**Proposed student accommodation and residential flat building
175 – 177 Cleveland Street, Redfern**

I refer to our BCA capability report dated 1 May 2014 and the letter from NSW Planning and Environment dated 9 September 2014 requesting further information.

Geoff Smith
Building Certifier
Vic Lilli and Partners

LEVEL 03 @ 1:200

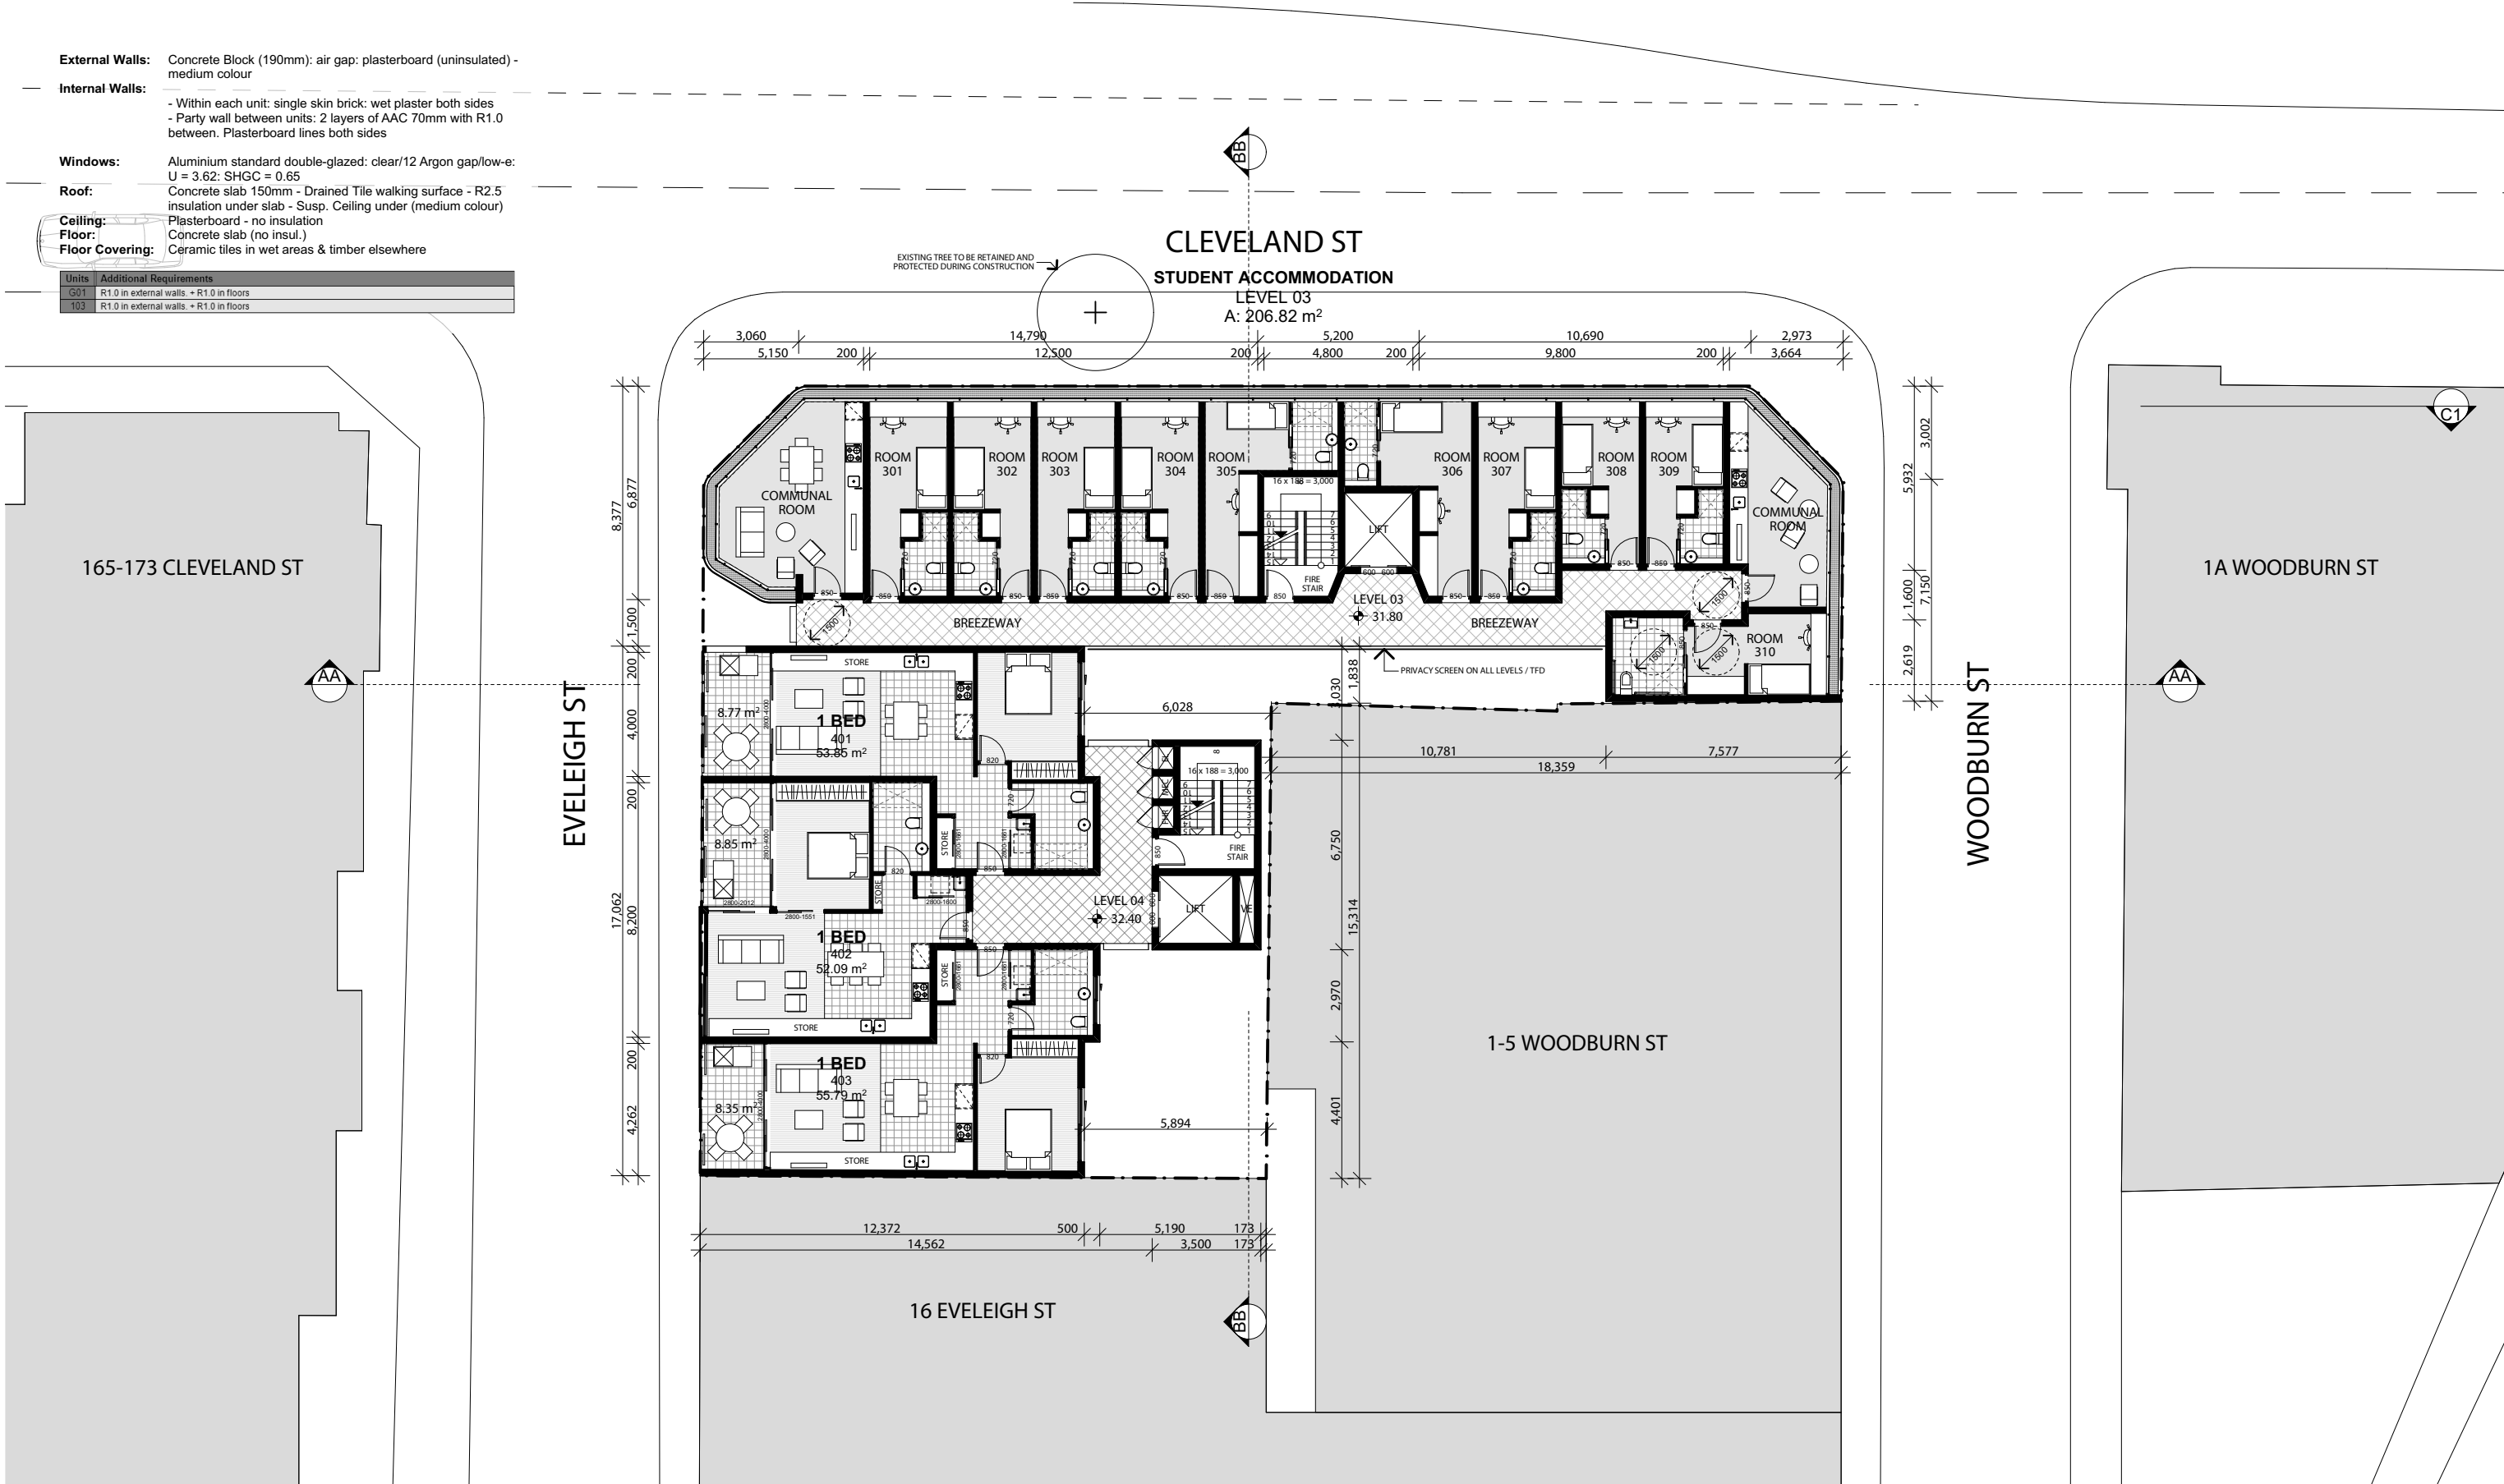
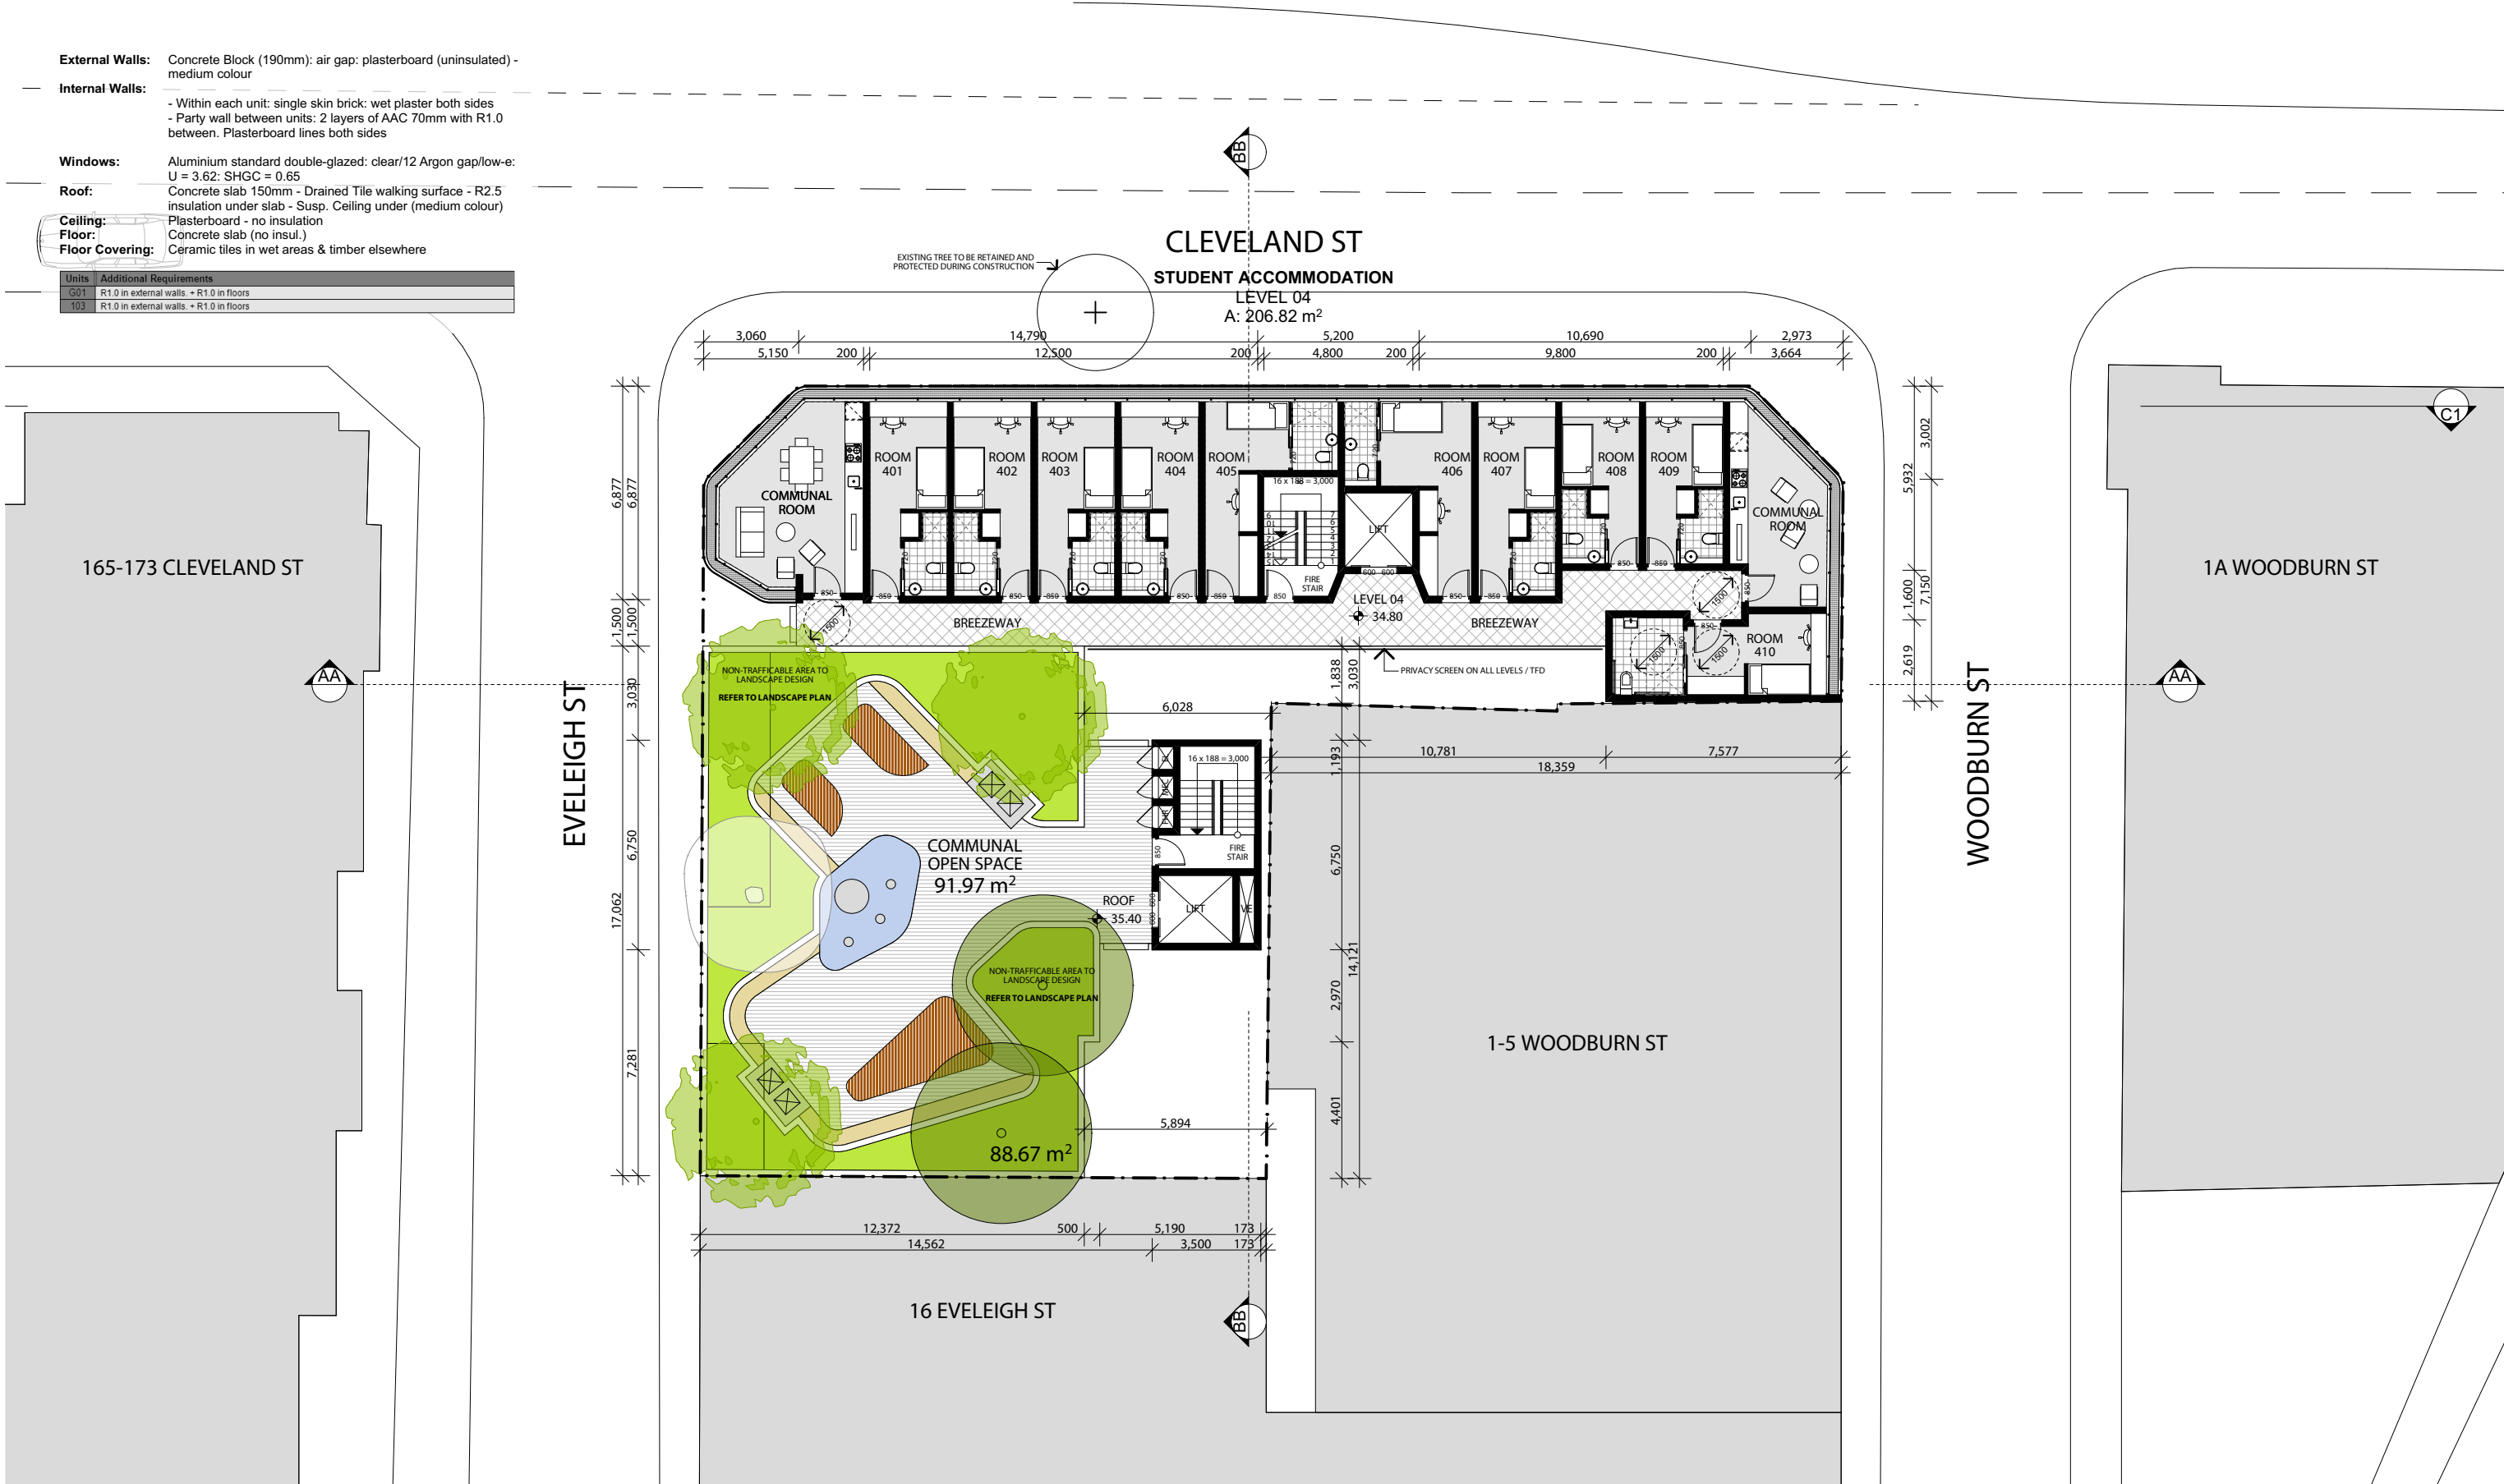
(i) The distance of travel from student sole occupancy units on levels 1-4 to the egress stairway is up to 13.5m which does not comply with the maximum of 6m permitted by BCA Clause D1.4.

I can confirm that compliance with BCA Clause D1.4 is proposed to be addressed via a fire engineered alternative solution which will demonstrate compliance with BCA Performance Requirement DP4. This will occur at the time of issue of construction certificates.
